From: Simon Davis
Sent: 01 March 2018 10:41
To: Planning.Responses
Subject: FW: Y/52/17/DOC - Longacre, Maypole Lane

Further Drainage comments

From: Paul Cann
Sent: 01 March 2018 10:12
To: Simon Davis
Subject: RE: Y/52/17/DOC - Longacre, Maypole Lane

Soakaway Section for Soakaway S(1)
Scale 1:25

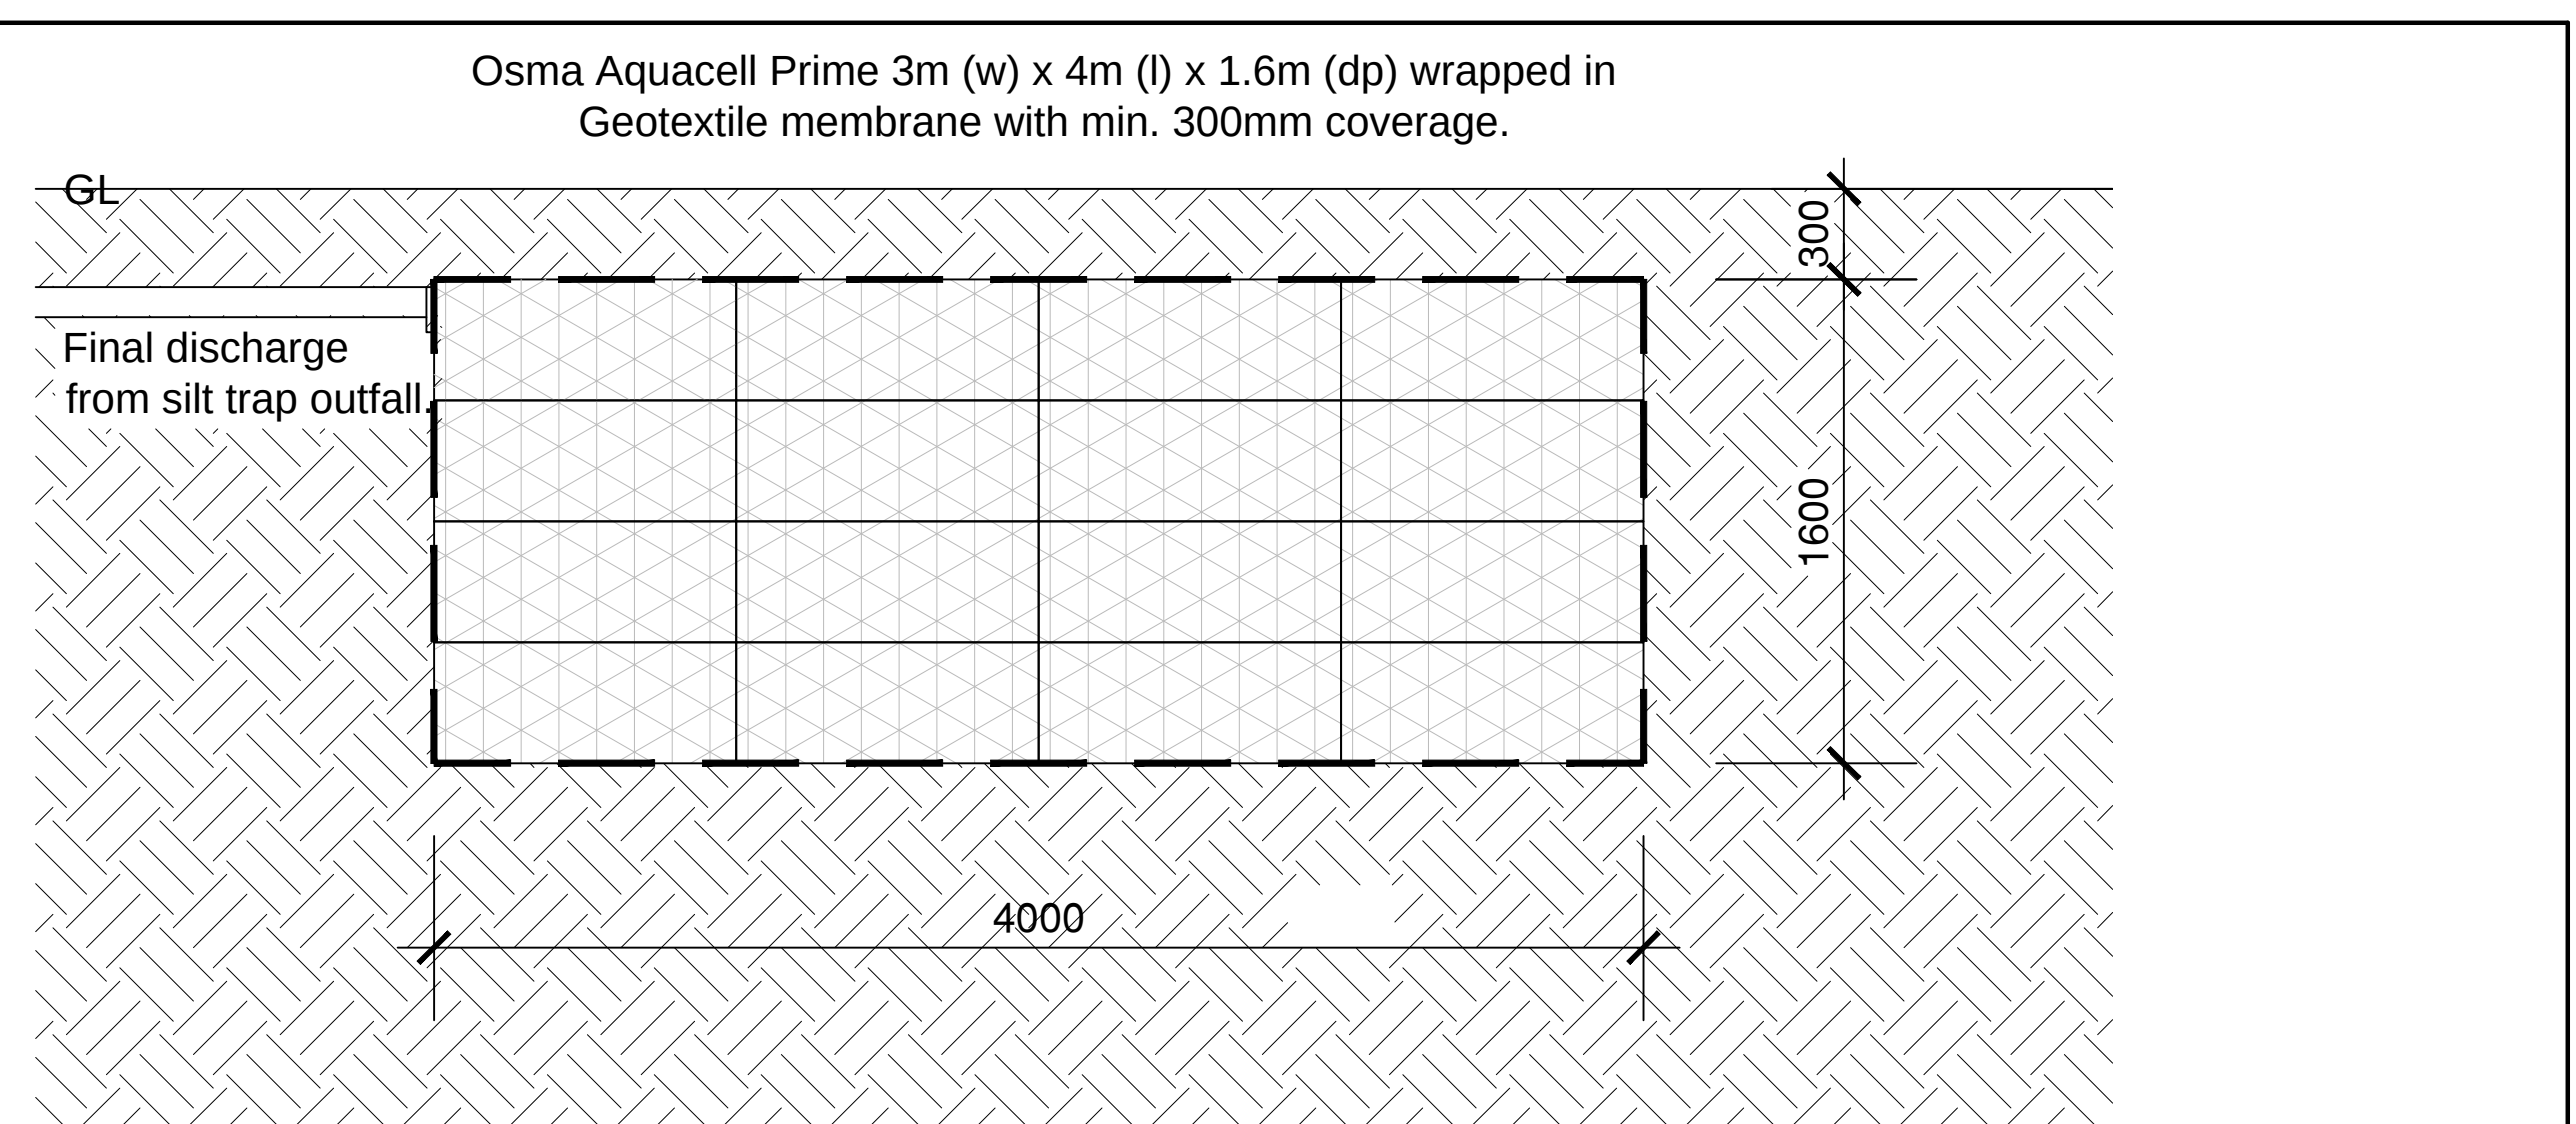
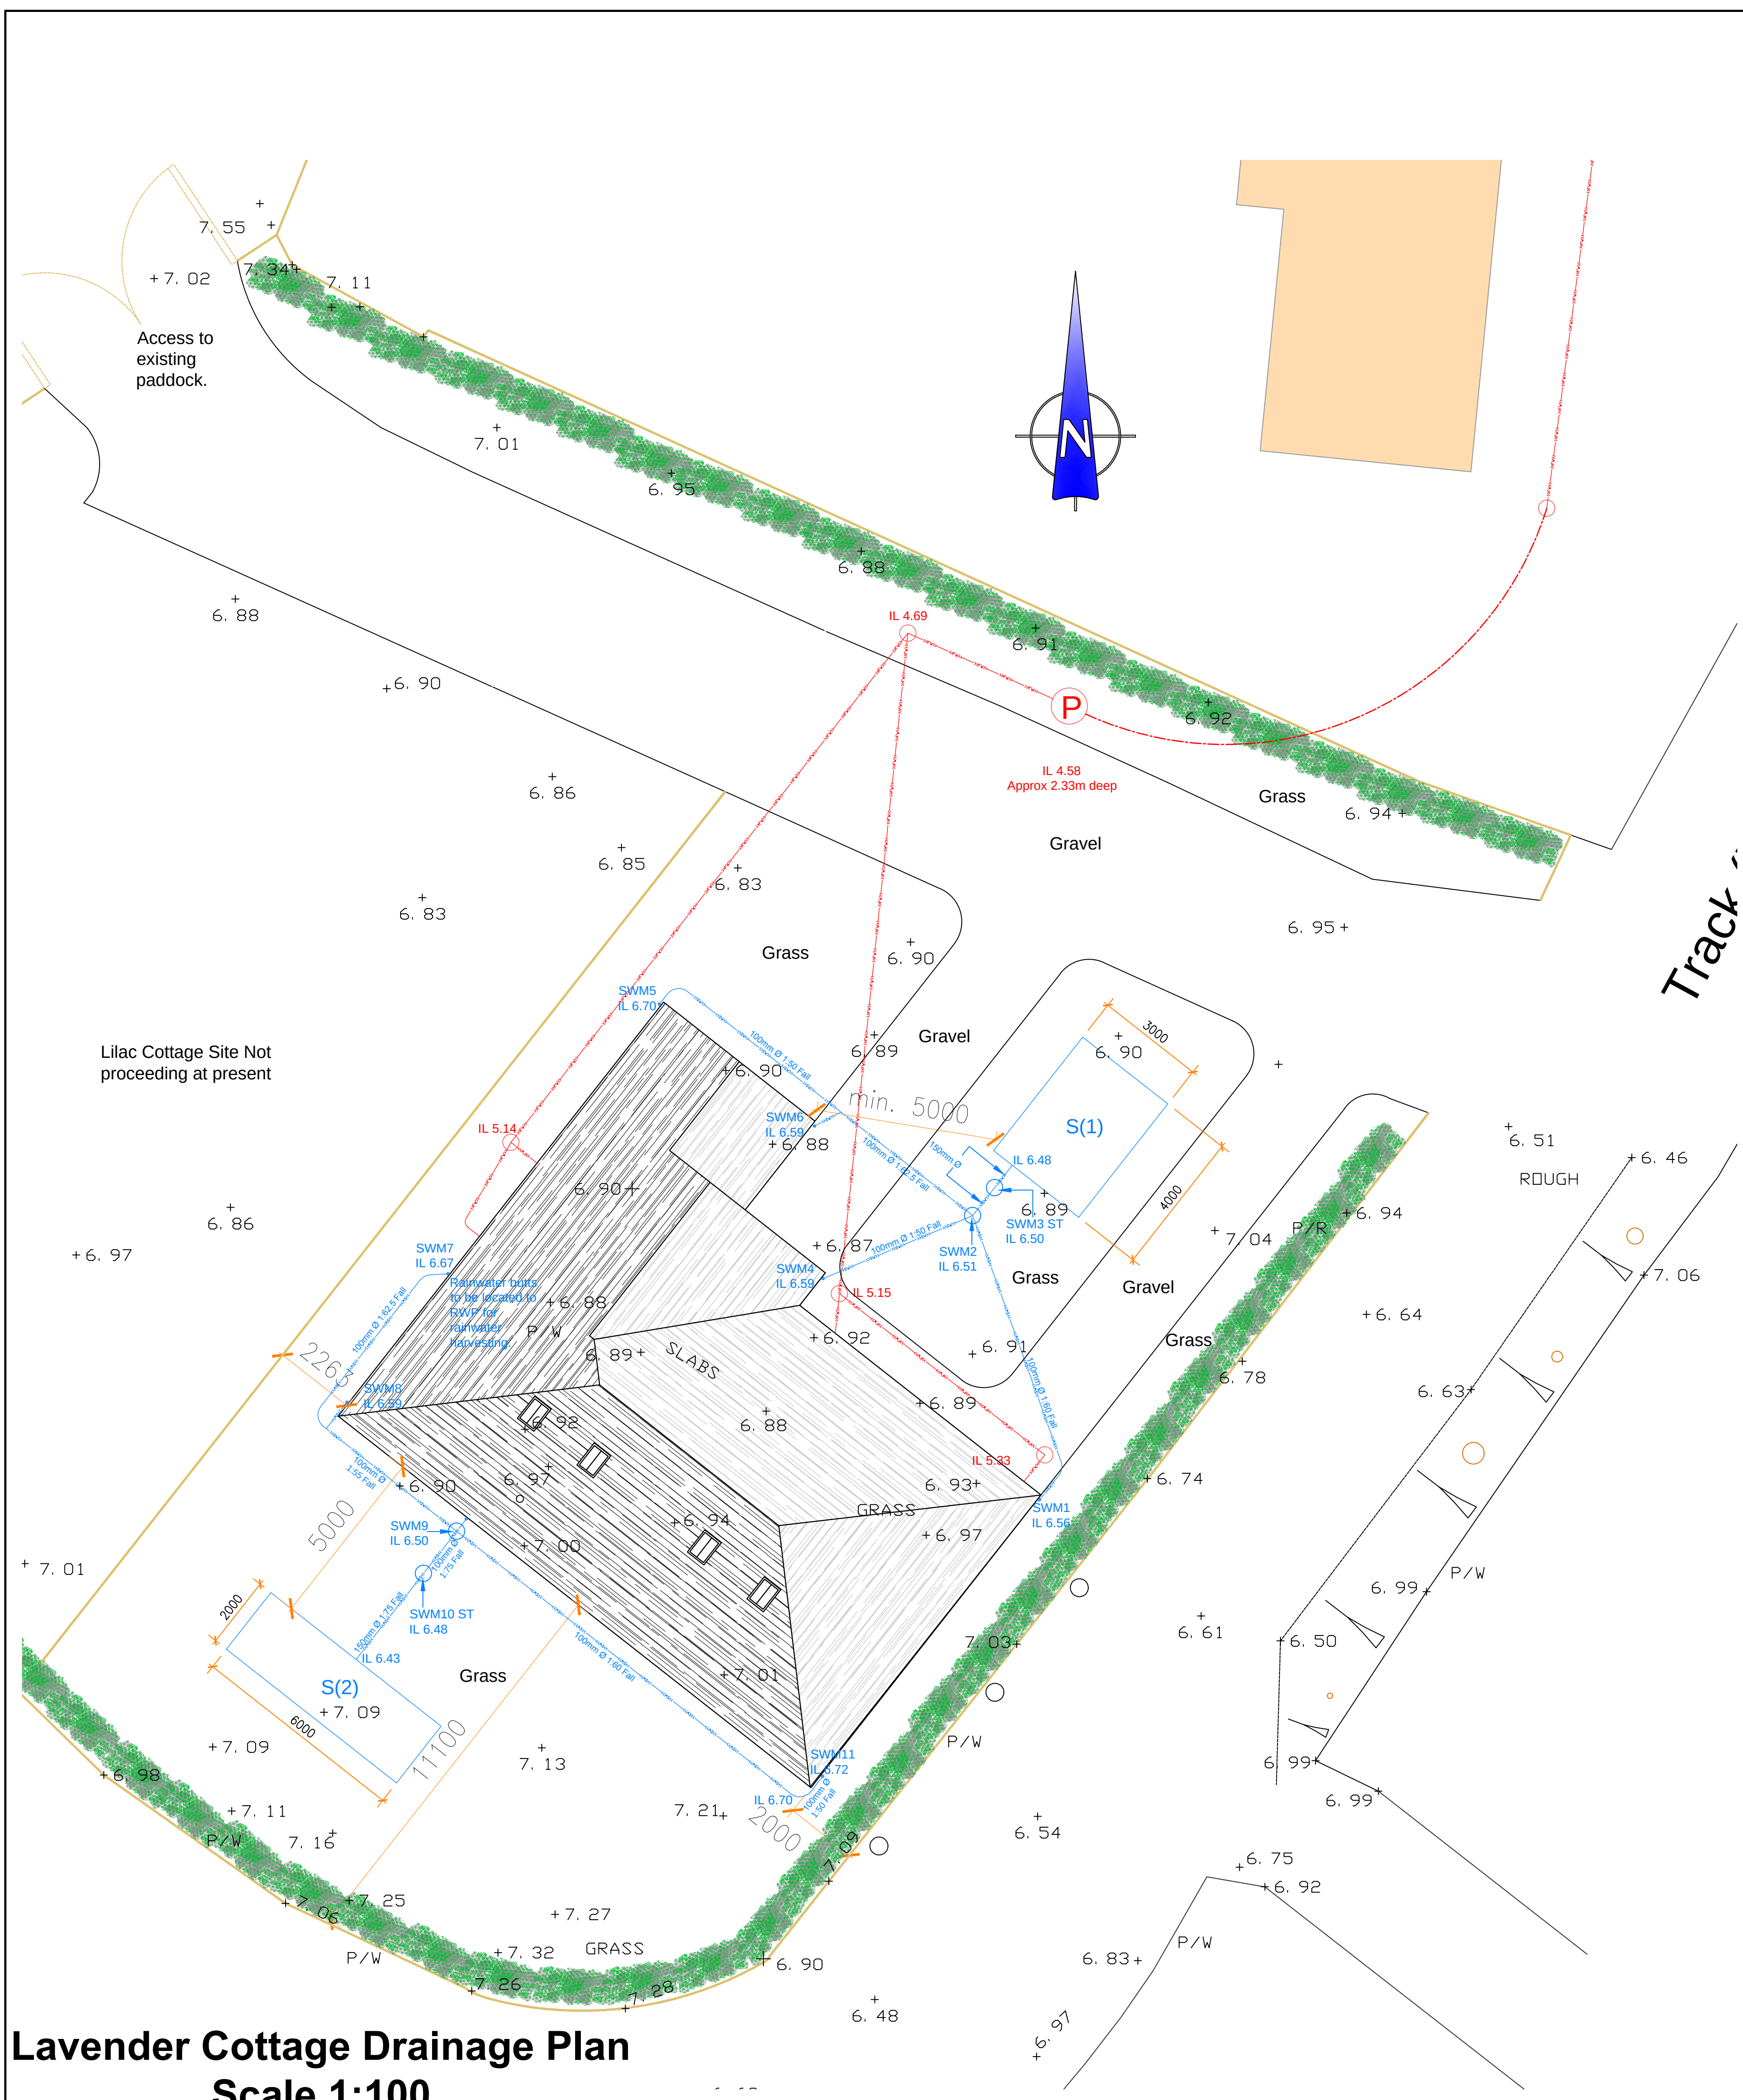
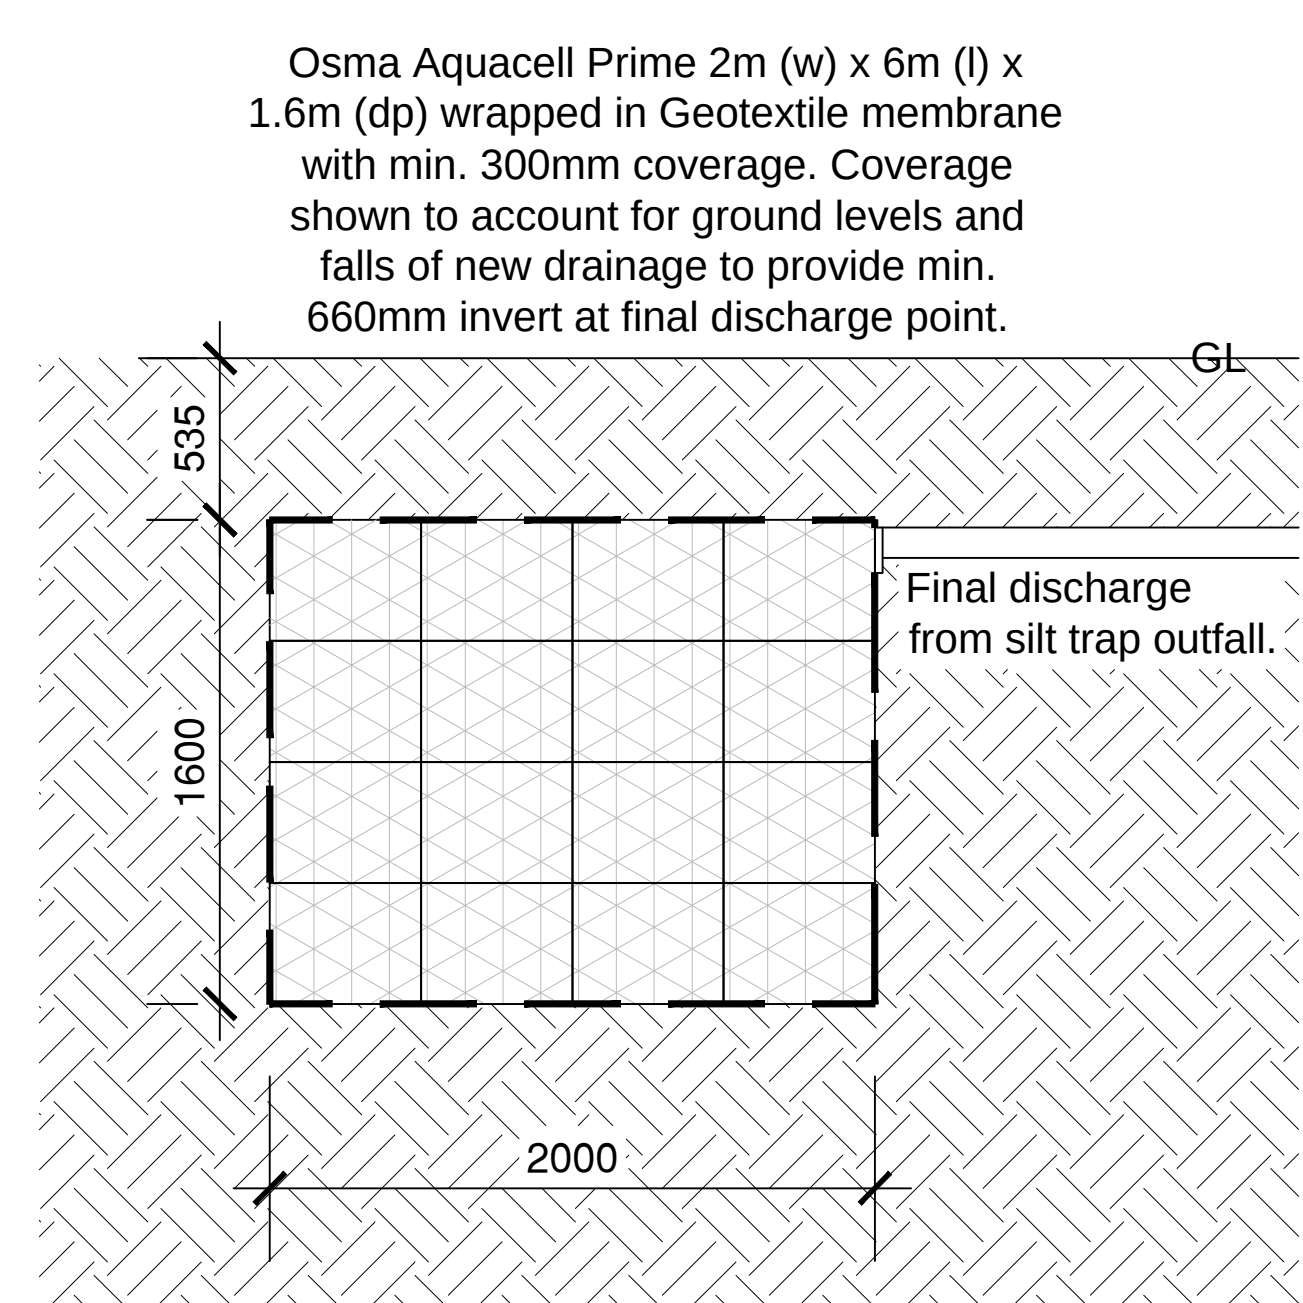
1. Alter soakaway detail to make it clear that a 'permeable' geotextile membrane is to be used.
2. Include a construction detail for the permeable paving, with the type 3 stone fully wrapped in permeable geotextile.

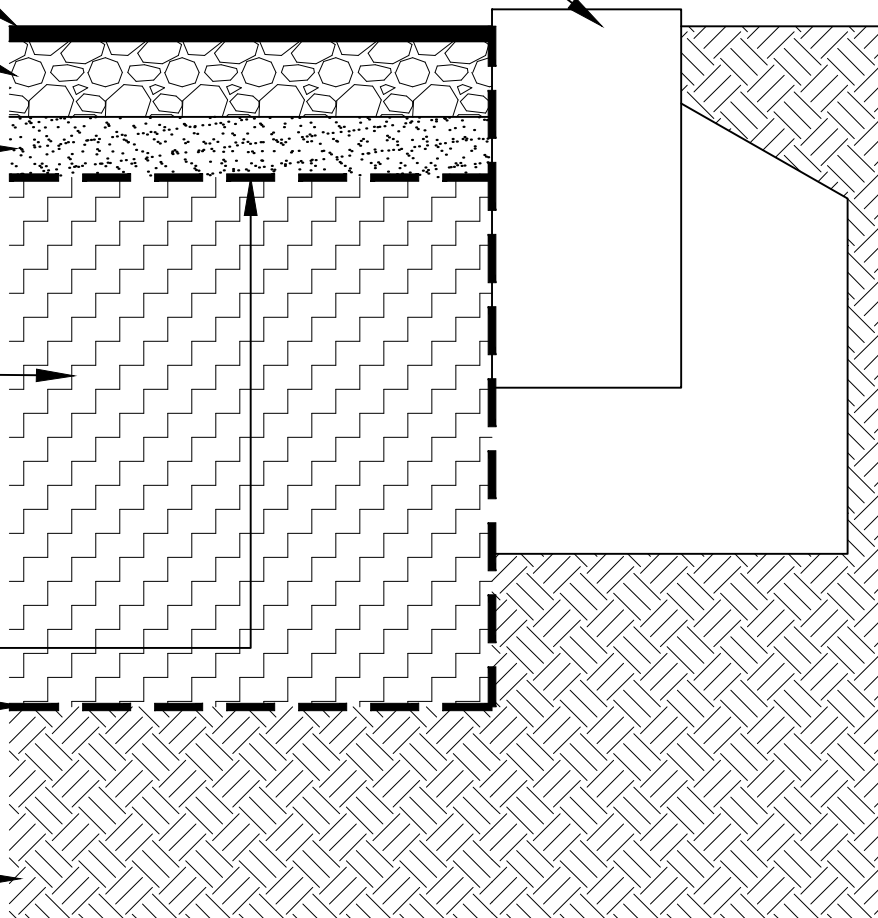
3. Specify finished levels for the permeable paving to show that any surface slope does not compromise the available storage in the type 3 stone.
4. The calculations for the permeable paving storage are slightly confusing in that the free volume for the type 3 stone is shown as 50% rather than 30%. There is also reference to 95% voids. Please clarify/correct as necessary. I have carried out my own calculations to confirm that the design storm can be accommodated within the type 3 stone (subject to the findings of item 3), however, the calculations supplied just need to be clear for future reference.
